From: [REDACTED]
Sent: 12 December 2019 13:55
To: Planning.Responses <Planning.Responses@arun.gov.uk>
Subject: FP/239/19/PL Felpham Site 6 Westmorlands Drive Felpham

RE: Felpham Site 6 Westmorlands Drive, Felpham.

Thank you for your correspondence of 20th November 2019, advising me of a ' Variation of Condition 15 imposed under FP/92/04 for bus gate (approved Phase 2) to be replaced with an emergency access & cycle link ' at the above location, for which you seek advice from a crime prevention viewpoint.

PROPOSED AUTOMATIC RISING BOLLARD DETAIL
Scale: 1/10

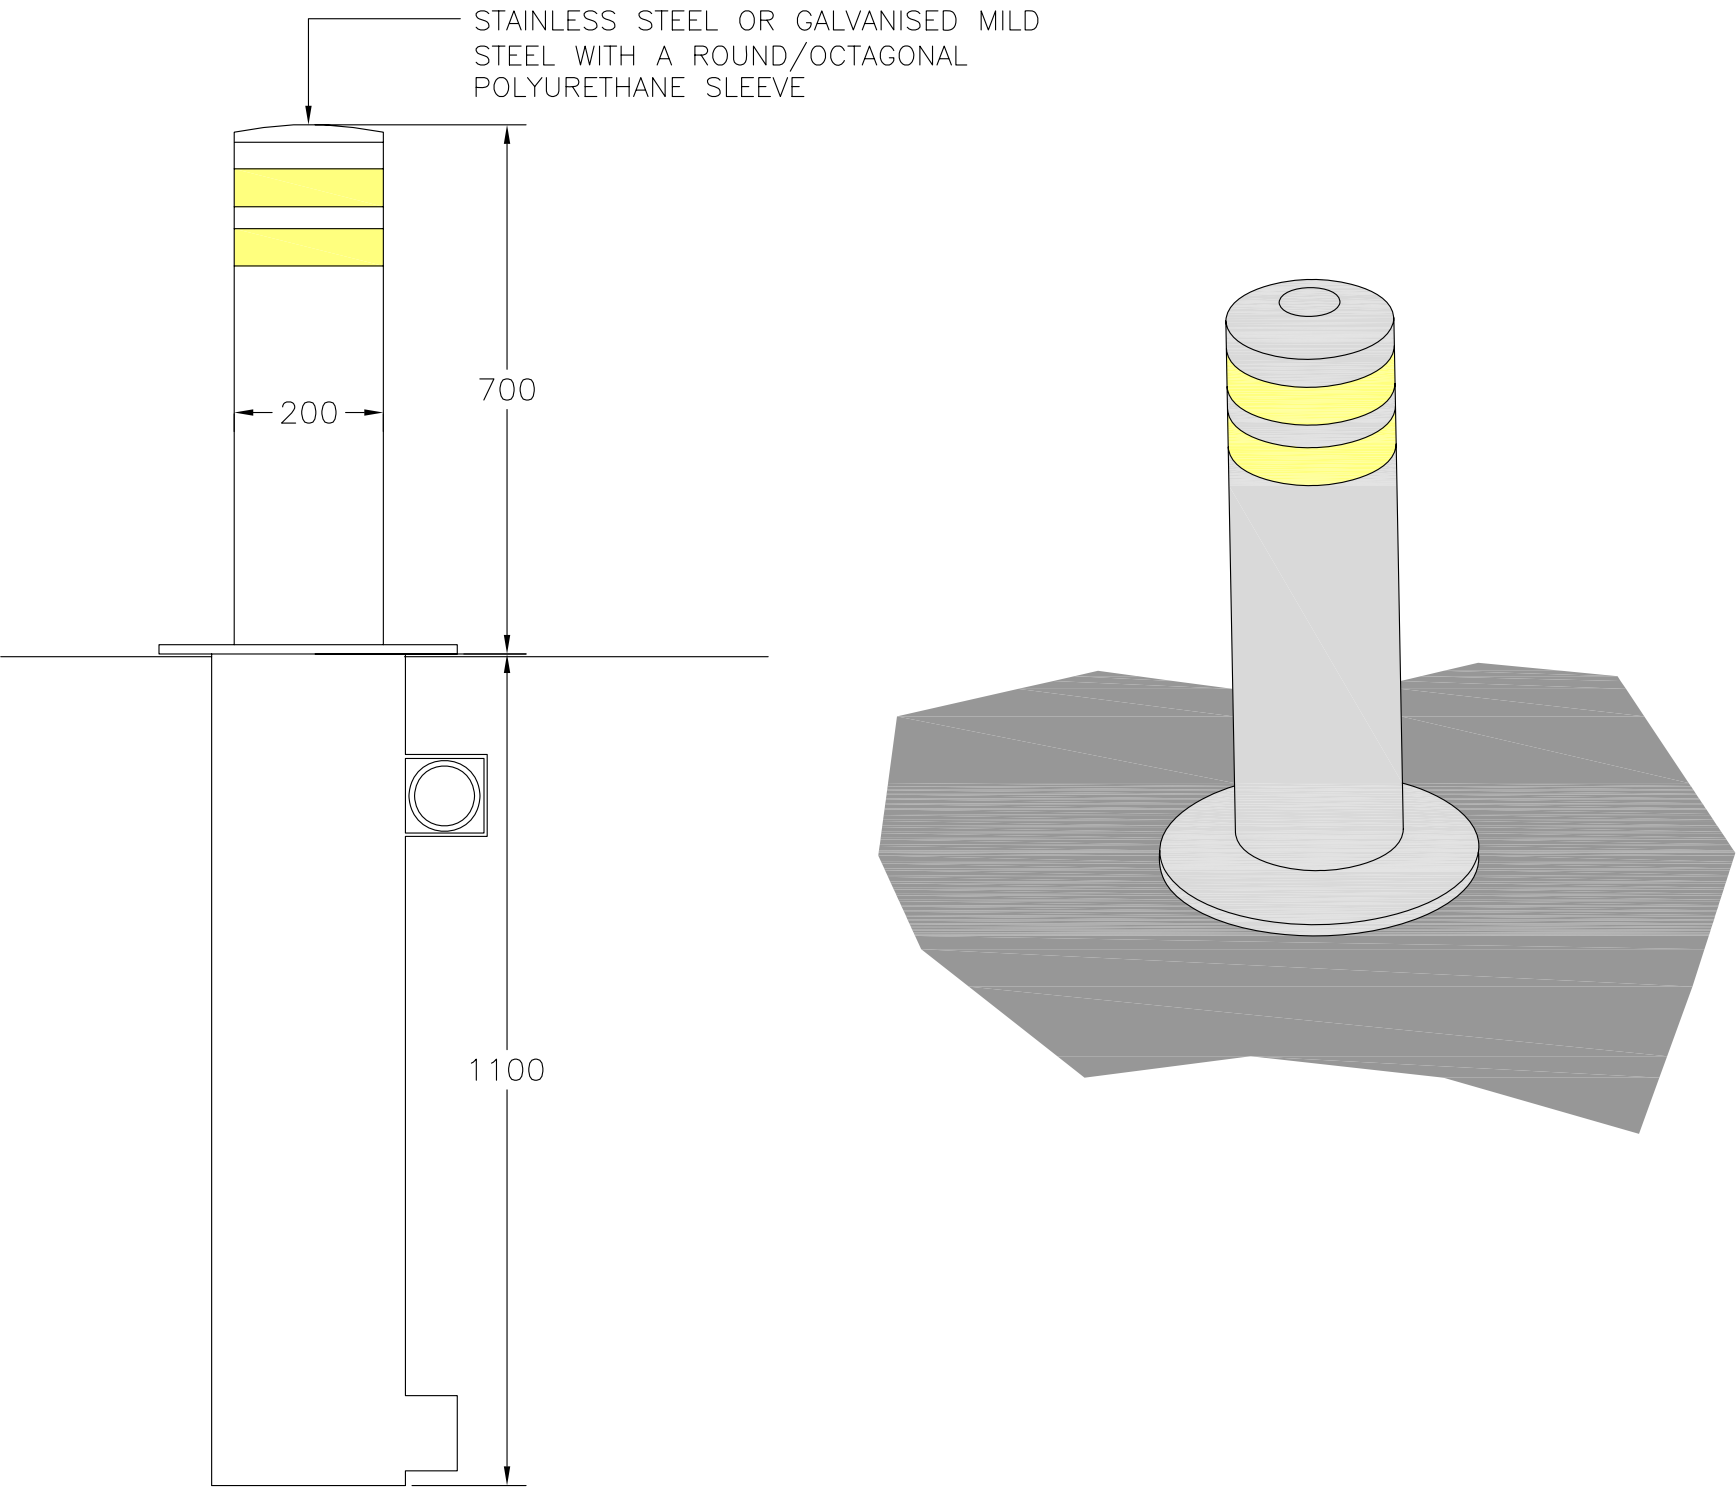
wheel chairs, pedal cycles and mobility vehicles. I note the access gap for the footpath gate design allows 1.5 metres through the chicane.

My only concern is that it may be large enough to allow small trials type motor cycles through it.

The proposed hinged swinging vehicle gates must be fitted so as to prevent the gates being lifted off their hinges and provision must be included to hold the gates open if required. The gates should open inwards away from the direction of traffic flow.

There should be no easy access on each side of the gate support posts which would allow vehicles to bypass the gates, such as driving across open grass verges. Gates and support posts must be constructed of galvanised heavy weight steel construction fit for purpose and firmly secured in the ground to prevent them being lifted out.

The gates must have access control, and if held closed by padlocks I would recommend each gate padlock is located in a steel box welded to the gate frame. The box should have an open end facing downwards so that the padlock can be attached within it and prevent the padlock hasp being attacked by saws or being levered. The only accessible point being from the bottom of the close fitting box. I recommend the key hole for the padlock is located at the bottom of the padlock to allow this type of fitting which will help provide an external layer of security around the padlock.

I recommend a minimum padlock specification should be Sold Secure 'Silver' or 'Gold' standards.

I also refer the applicant to SBD (Commercial Developments 2015) document and to (Para 45.1 bullet point 3), and (Para 45.2) in regard to appropriate selection and installation of bollards.

Appropriate traffic warning signage must be provided at each side of the gate to provide conditions of use and for warning of the obstruction to traffic.
